From: Mark Warwick [REDACTED]
Sent: 09 December 2019 11:11
To: Brigitte Crafer <[REDACTED]>; Nick Clews [REDACTED]
Cc: Simon Davis [REDACTED]
Subject: AW/55/18/HH - Pre-commencement site meeting 9th December 2019

Reference is made to the approved plan: Tree Protection Plan, dwg.no. 1035-5400 Rev A.

PROPOSED PLOT PLAN

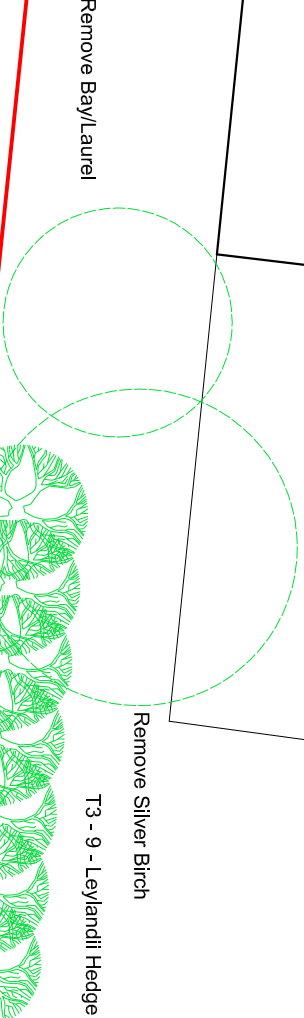
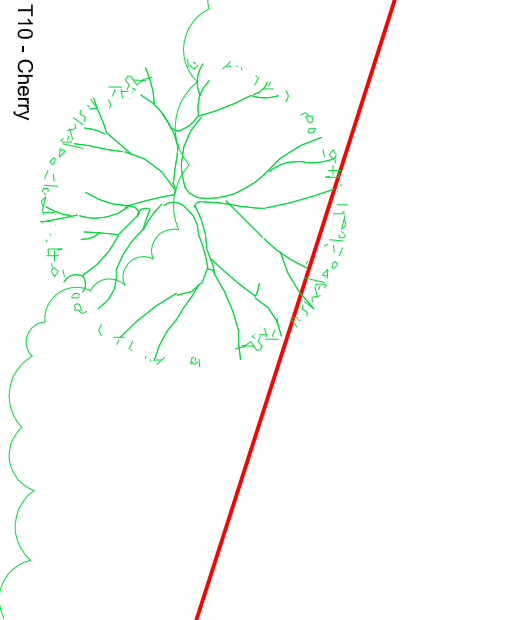
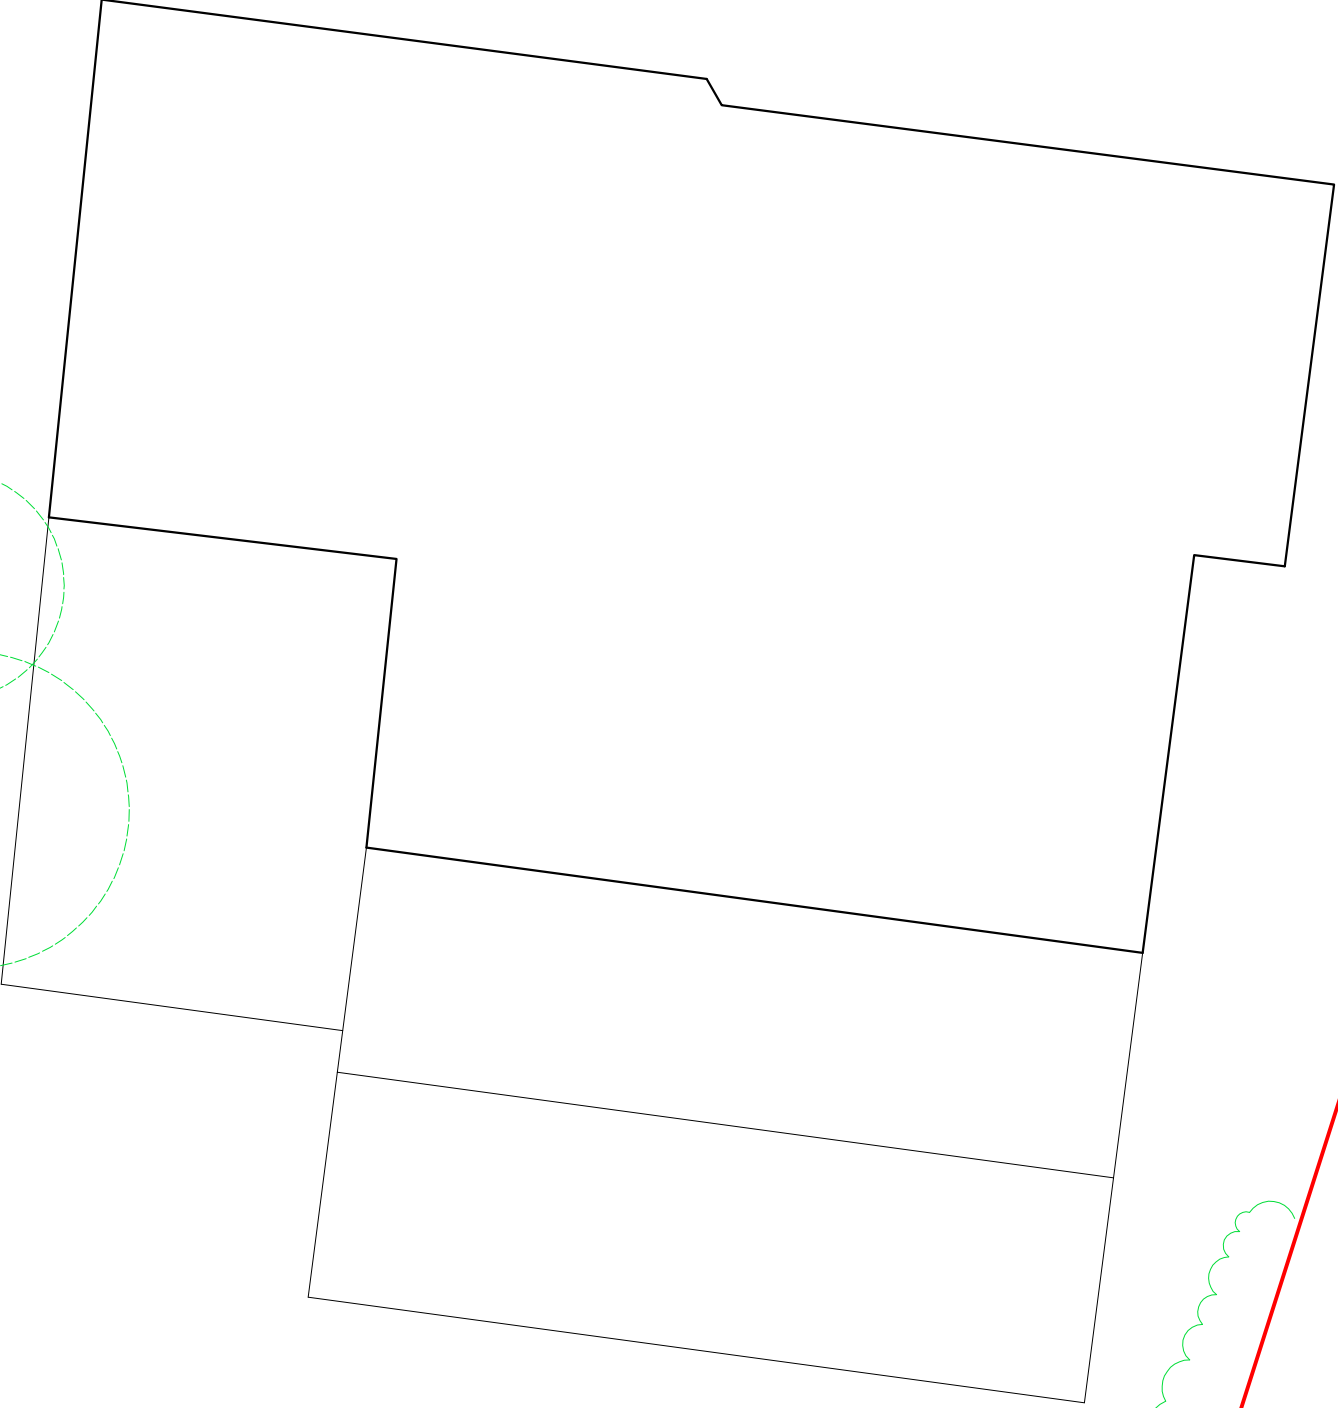
2. Advice was given to all in relation to the treatment of tree stumps T1 bay laurel and T2 birch. Due to proximity to retained cypress hedge T4, T2 stump is to be carefully ground/cut down to no more than 150mm below adjacent ground level and confined to the central core of the stem base, to limit potential for damage to live roots. T1 can be either be ground down to full depth (approx. 300mm) or carefully extracted by mechanised plant if approached from the north or east aspect only.
